VARIATION OF CONDITIONS APPLICATION – LAND TO THE NORTH AND EAST OF WARREN MILL HOUSE, ELMSWELL ROAD, WETHERDEN

PERMISSION TO BE VARIED: DC/22/03101

CONDITIONS TO BE VARIED: 2, 5, 6, 7, 8, 9

DRAWING
PLOT 2 - PLANS & ELEVATIONS AS PROPOSED.

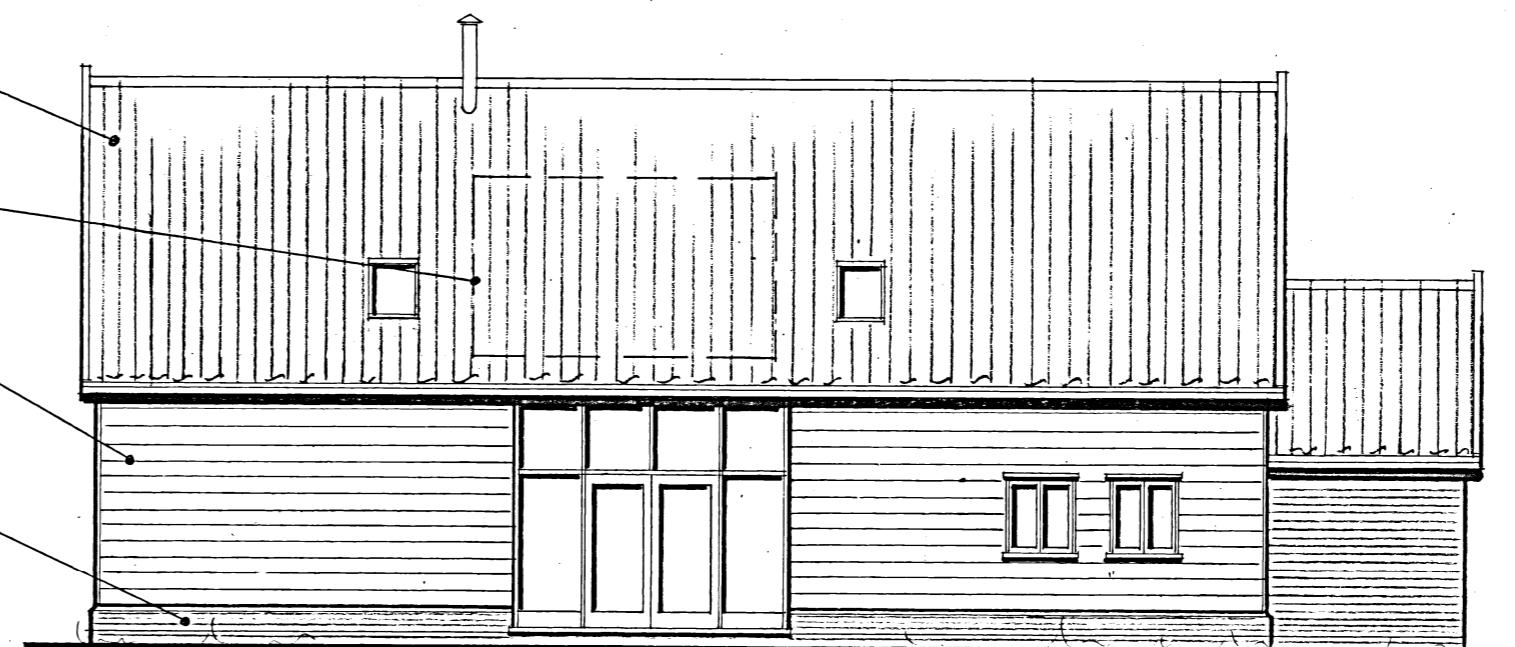
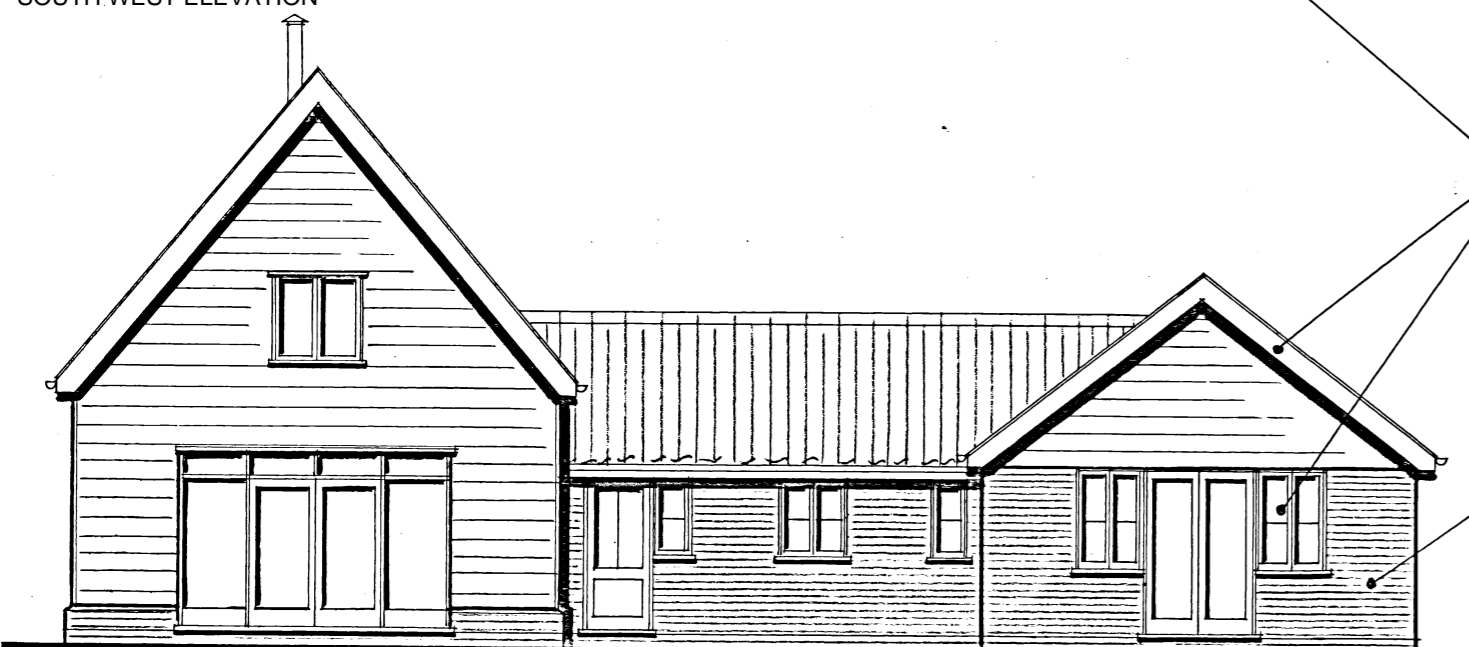
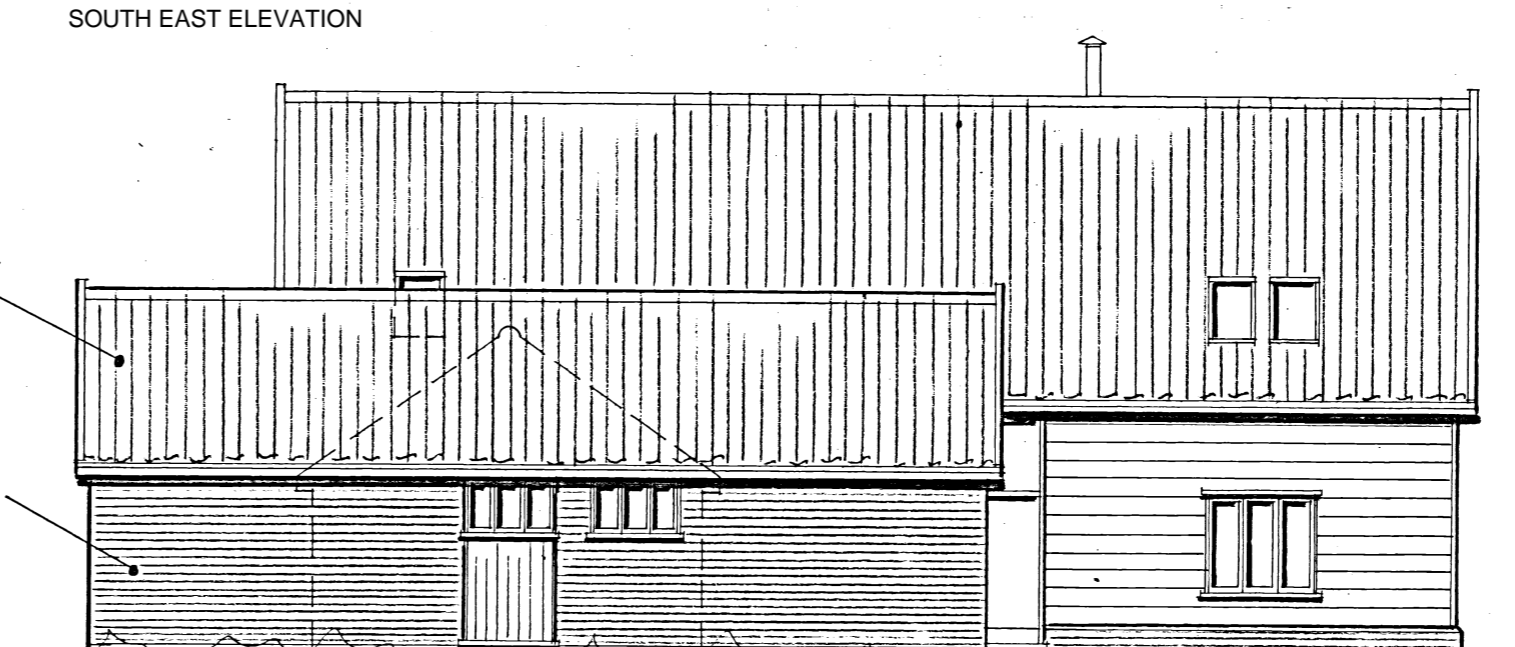
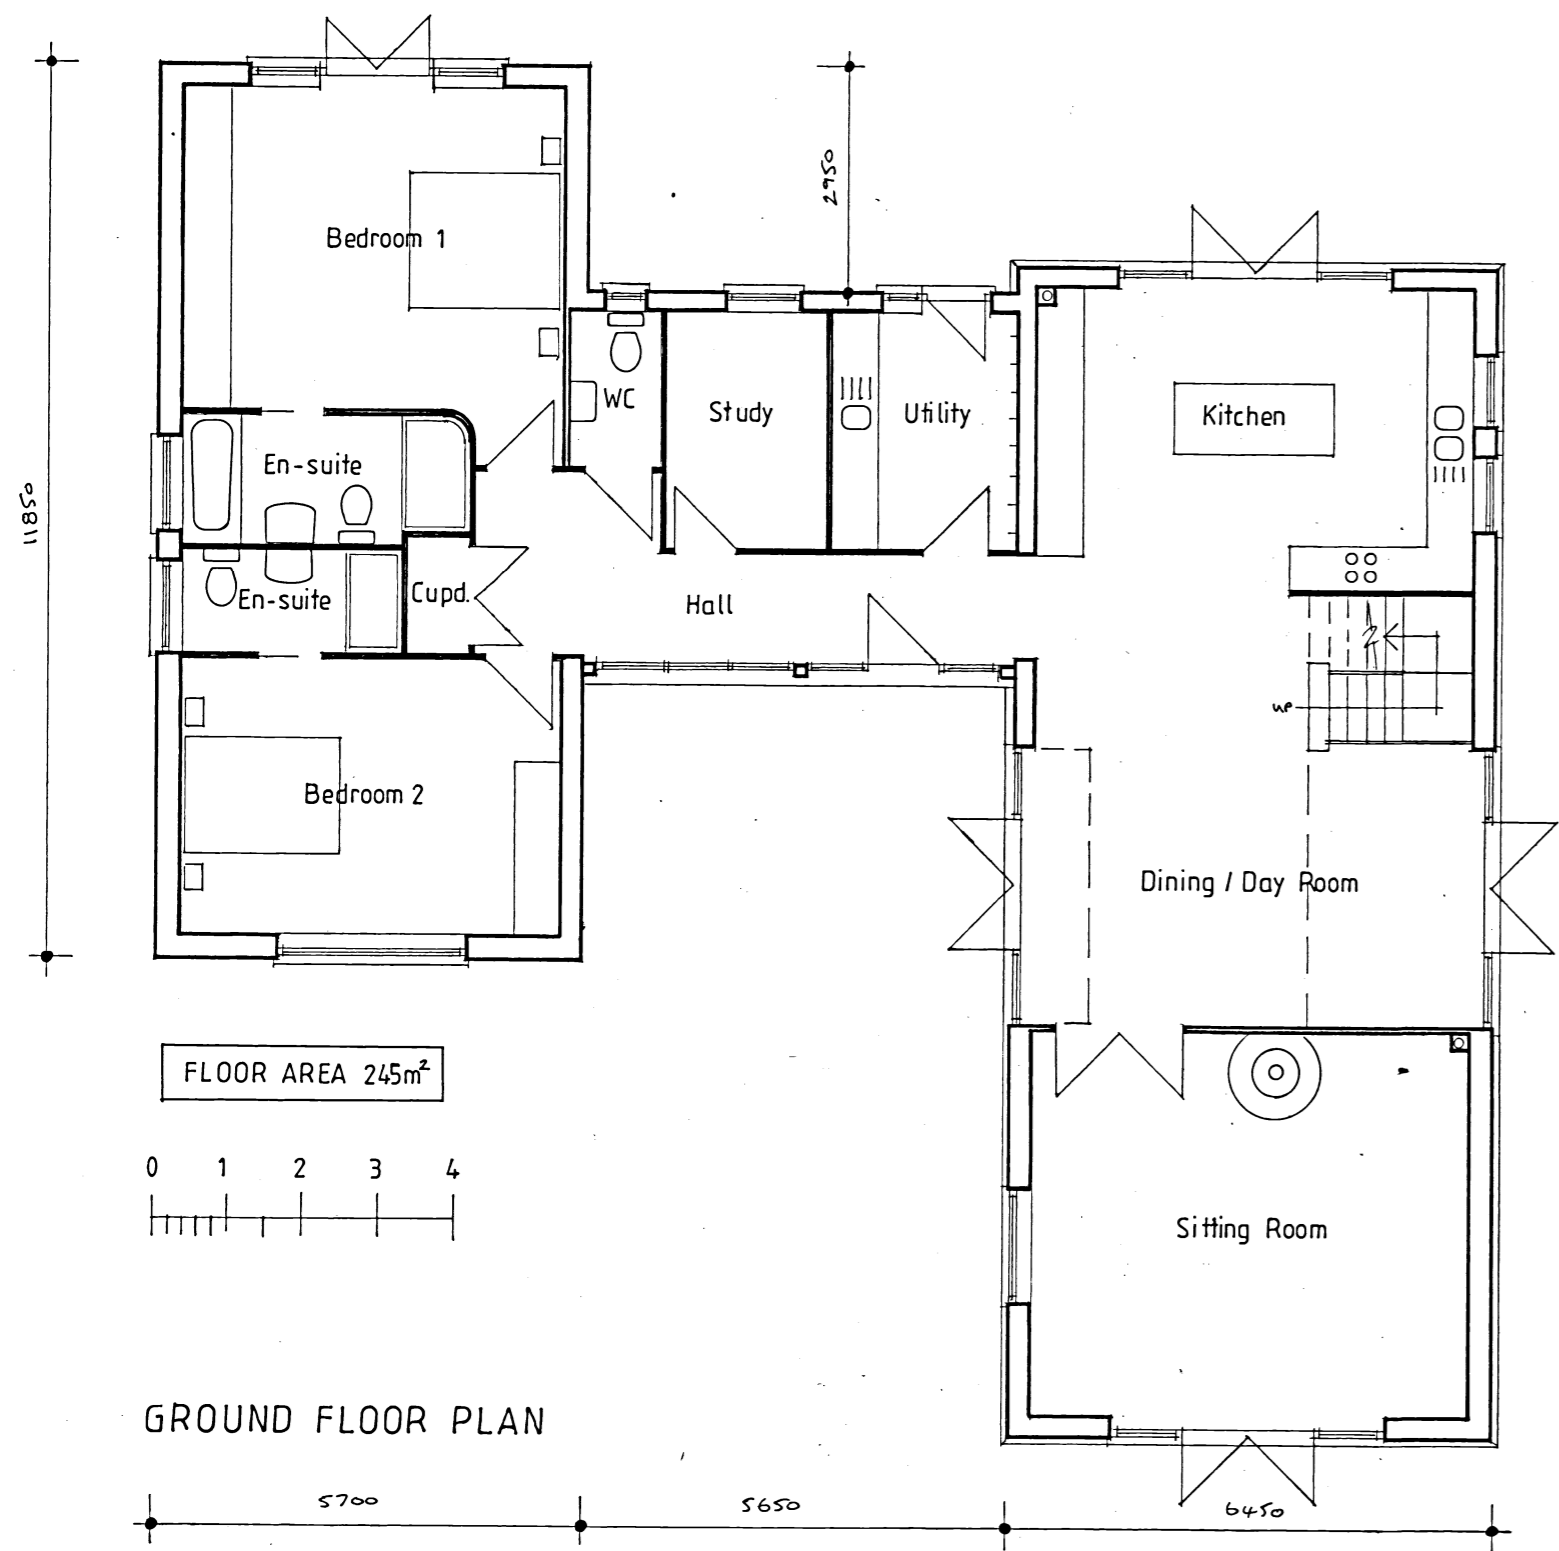
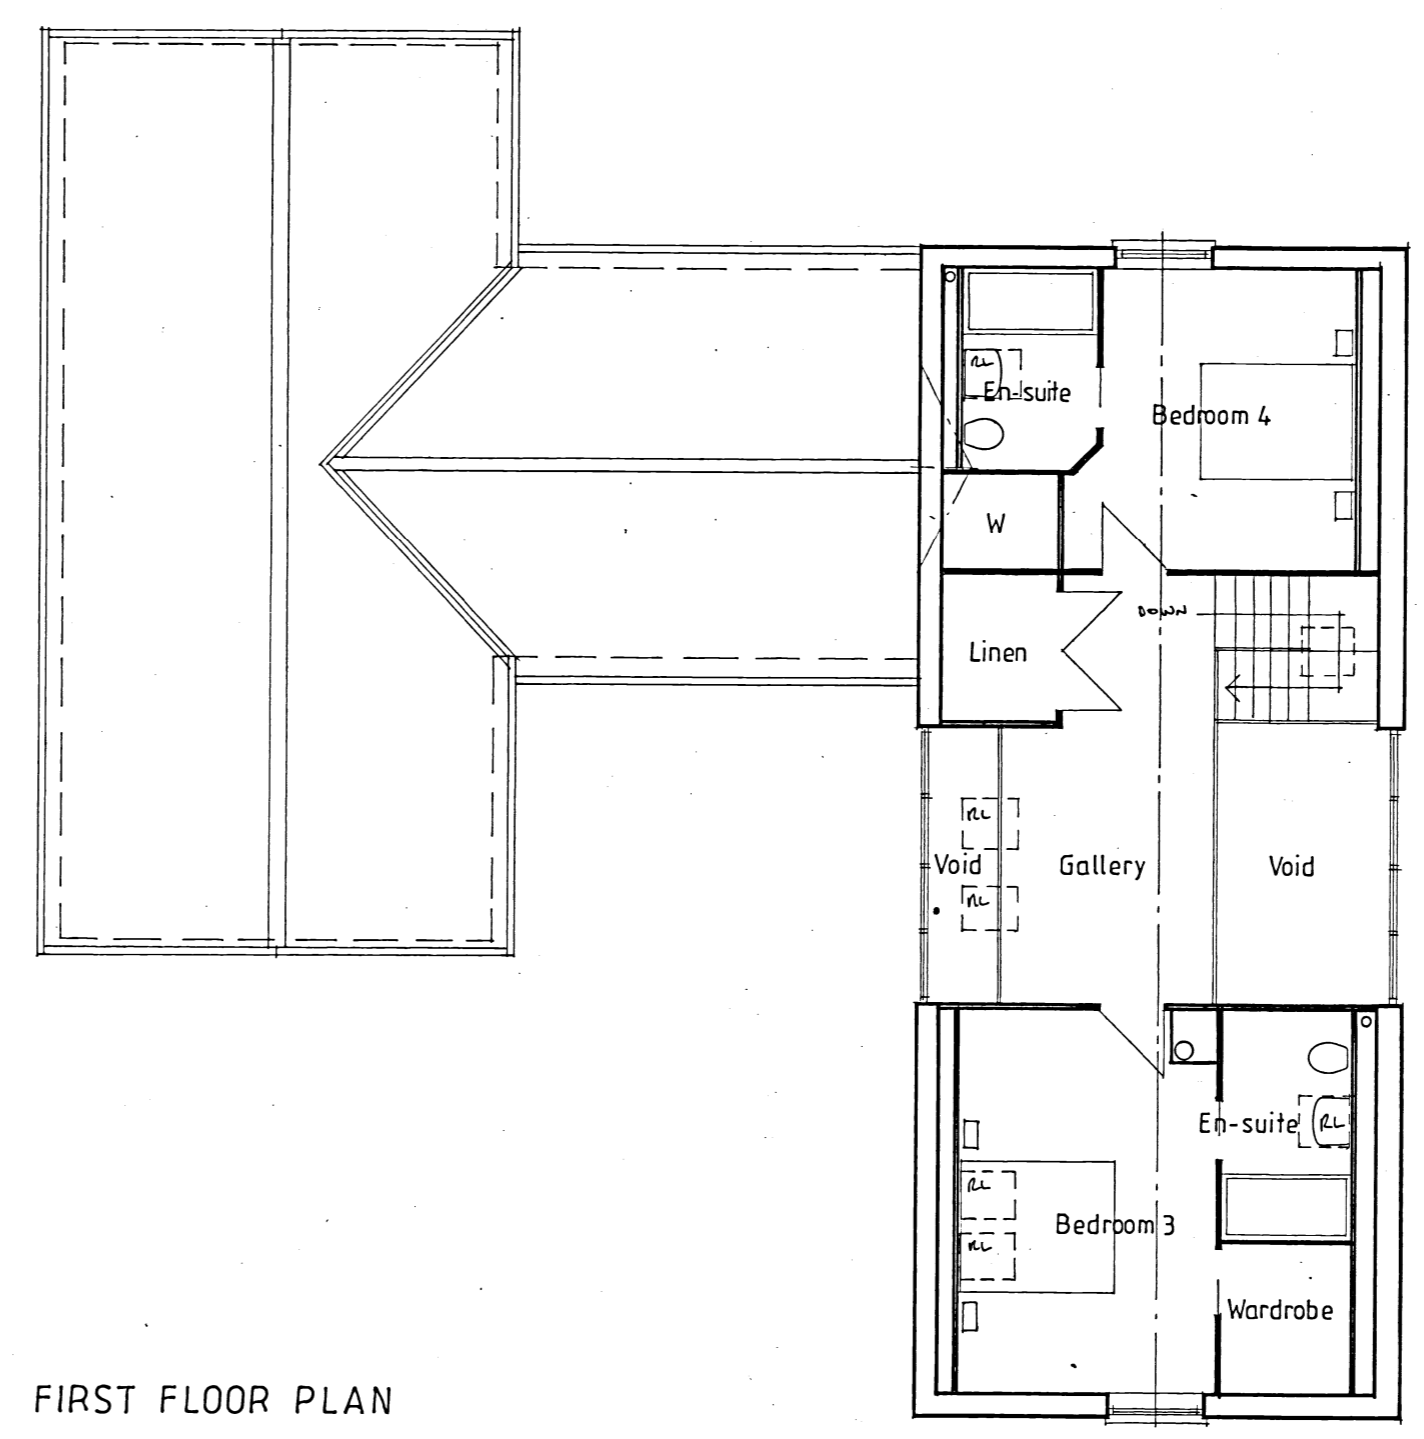
The impact of the changes on the wider landscape due to the updated design of Plot 2 will be minimal. As shown in Figure 3, the increase in height of the proposed ridge of Plot 2 is modest and the impact of this increase in height is reduced by rotating the house. This means this taller section of the building is perpendicular to the road, reducing the view of it, whereas, on the approved scheme, the highest ridge of Plot 2 ran parallel to the road.

This variation application seeks to make changes to the internal layout of the Plot 1 house type and to make better use of the internal space of the houses. The roof space has been utilised to provide additional internal floor area to provide another bedroom. This increases the floor area while reducing the footprint of the building as the utility room lean-to element has been removed. The footprint of Plot 1 is reduced from 210 sqm to 200 sqm. The height of the roof has only been increased by 0.3 m to accommodate the additional headspace required. Plot 2 is proposed to mirror the updated Plot 1 design and is a handed version of this.
